**From:** [REDACTED]  
**To:** [A303 Stonehenge](#)  
**Subject:** Support for submission from Roger Upfold (20018352) re details of design and surfacing of new and improved PRoW  
**Date:** 26 August 2019 23:26:03

To the Planning Inspectorate in connection with the current Stonehenge/A303 application and draft DCO

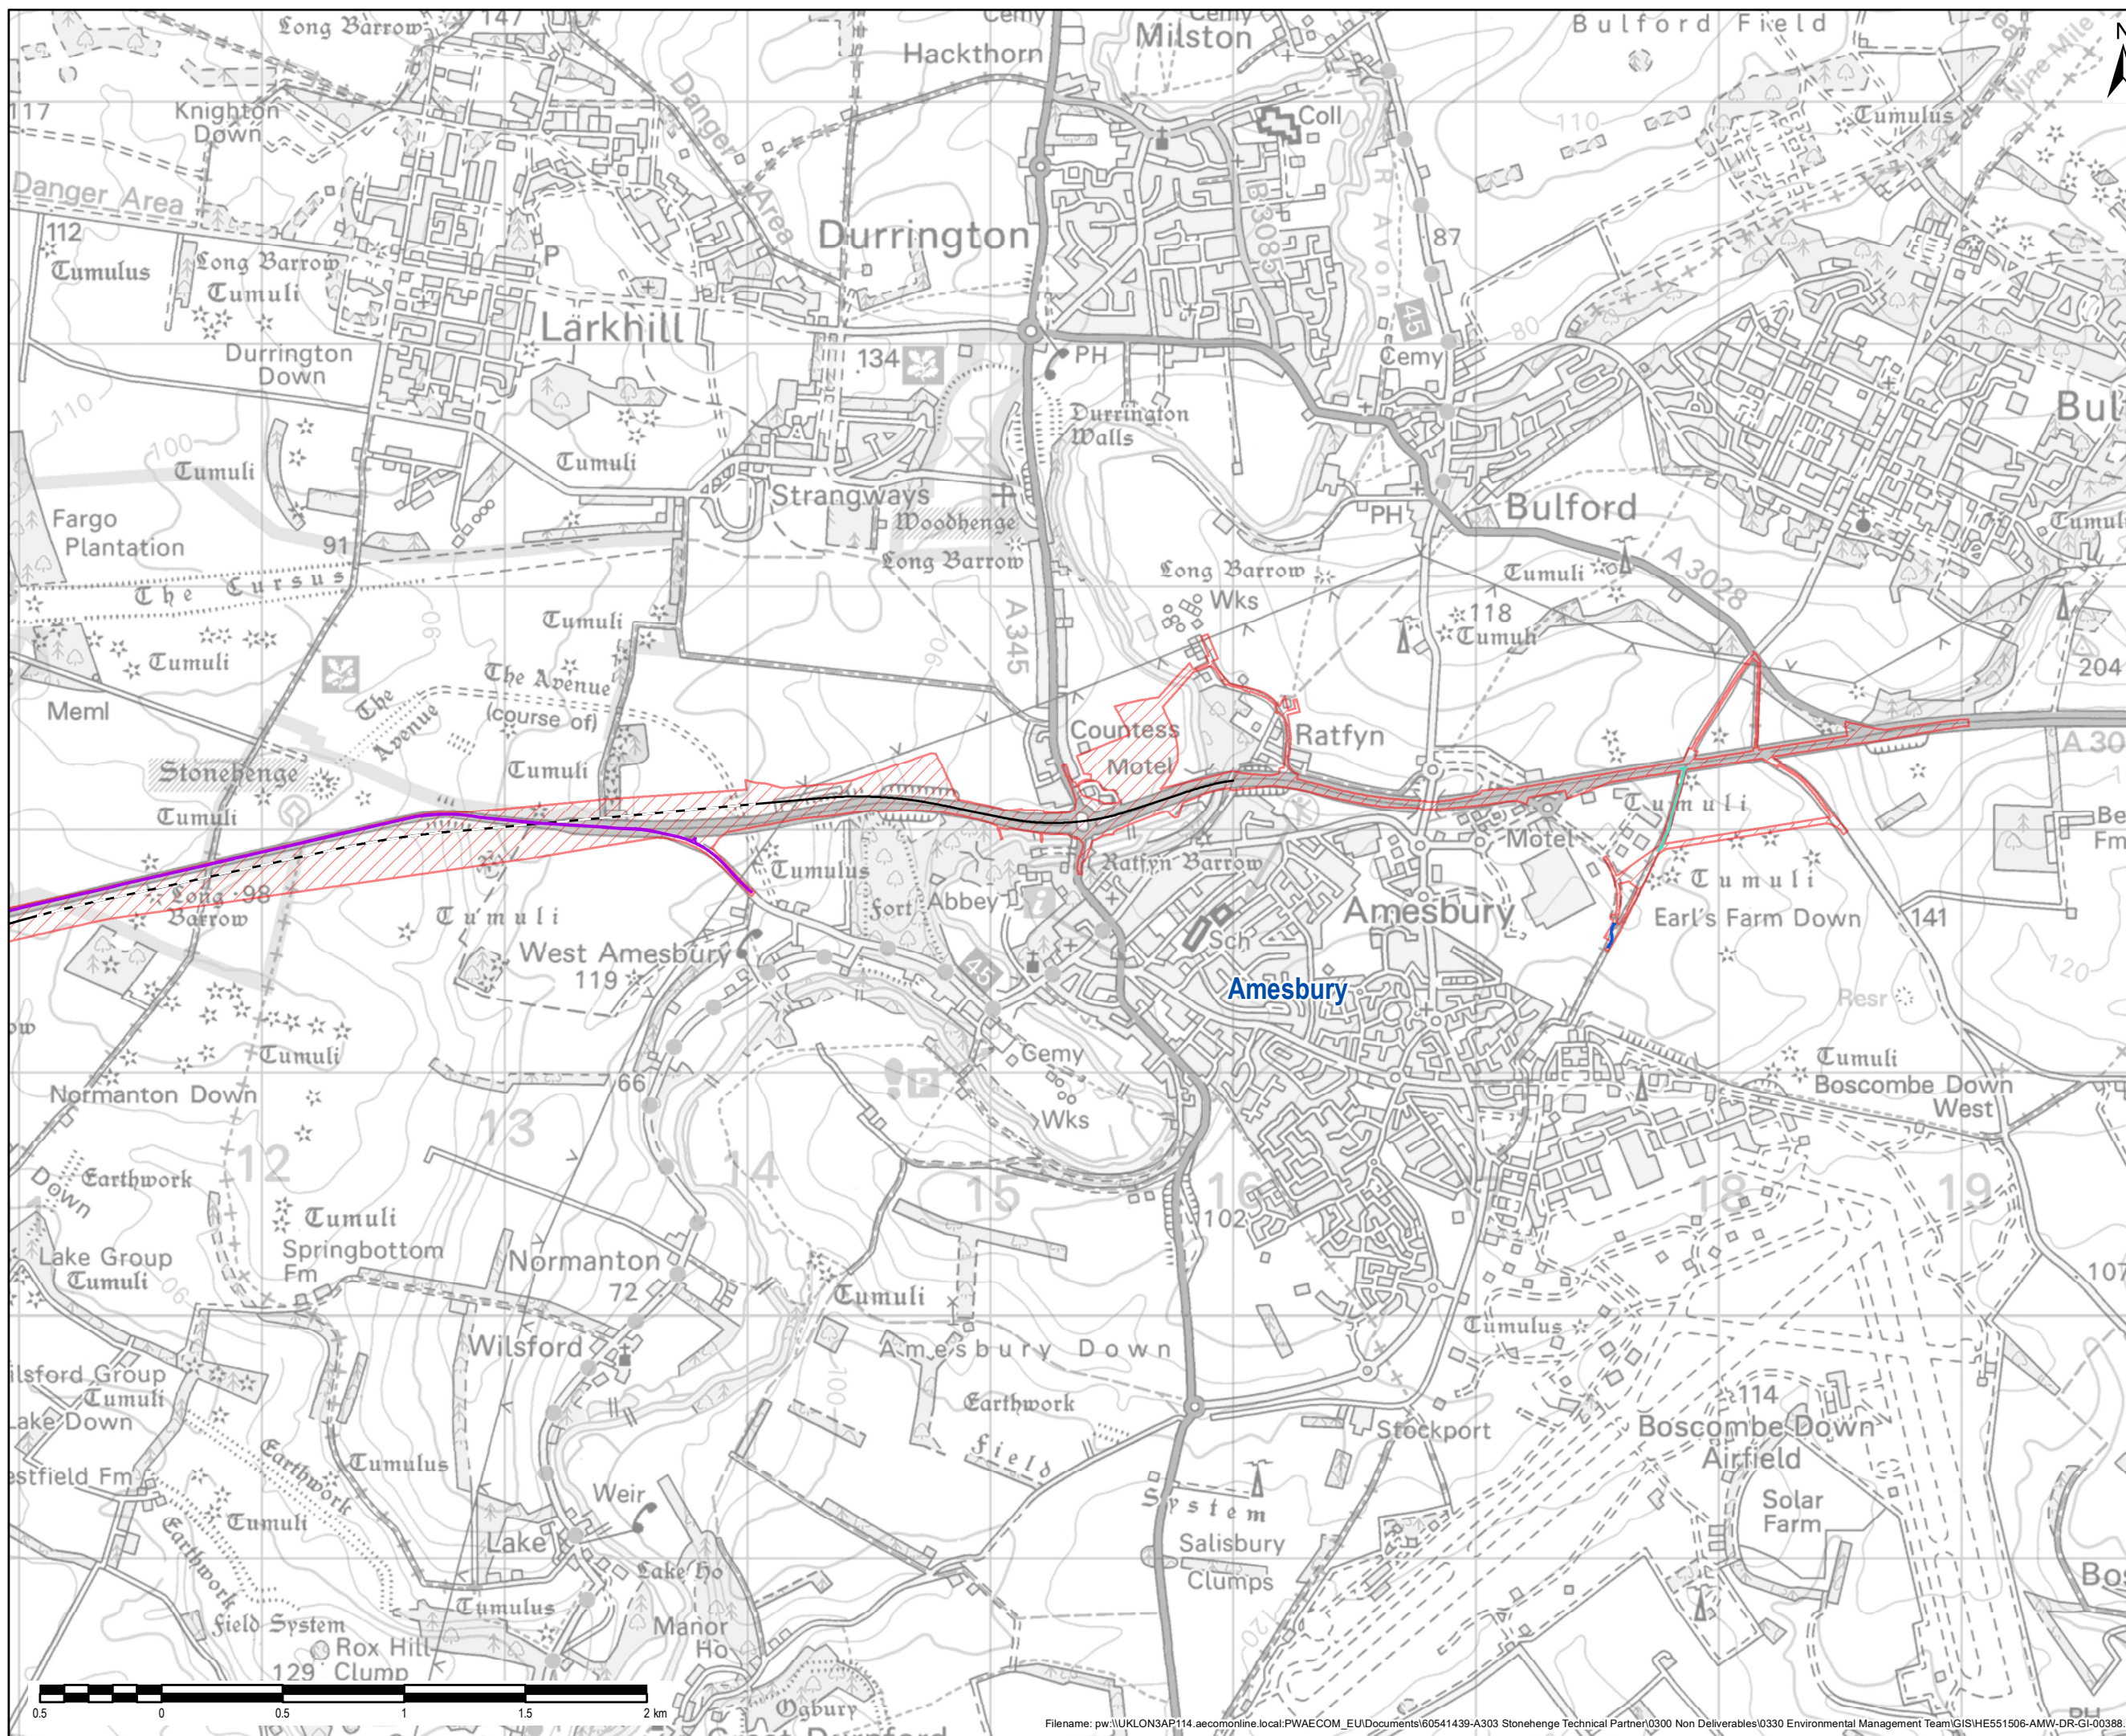
On behalf of the Cycling Opportunities Group for Salisbury, I wish to endorse and support Roger Upfold's submission regarding details of the design and surfacing of new and improved PRoW. We have been informed by Highways England during the consultation phase of the Scheme that these will be determined at the detailed design stage, but at that point, if not legally binding by inclusion in the final DCO, details could be subject to a number of constraints, not least budgetary, and there is a danger that the resulting construction might not meet the needs of NMUs who are excluded from using the tunnel. Mr Upfold's submission is copied below.

On behalf of cyclists and other NUMs, and in the apparent absence of specific content on the following issues in the draft DCO, I make a formal request in relation to the detailed content of the final DCO for the Stonehenge/A303 scheme, that it includes:

legally binding design and construction details (at minimum in the form of precise functional objectives to be achieved) on the characteristics of the new and improved Byways, Restricted Byways and Bridleways and their highway crossing points, with particular reference to: minimum widths, the nature of their surfaces (especially where they must be 'bound' to meet specific user group needs, as we have in previous submissions highlighted), drainage and vegetation aspects, to meet the needs of all NUMs both in the near future and much longer term, including likely growth in their use by NUMs

because if these matters are not covered in enough detail by the DCO and left to the detailed design stage there is a danger that the needs of NUMs may not be adequately met in the face of economic or other challenges/requests, and also because Wiltshire Council as the inheritor of these PRoW may be put in difficulties in meeting their legal responsibilities for their long term upkeep, especially those arising from climate change.
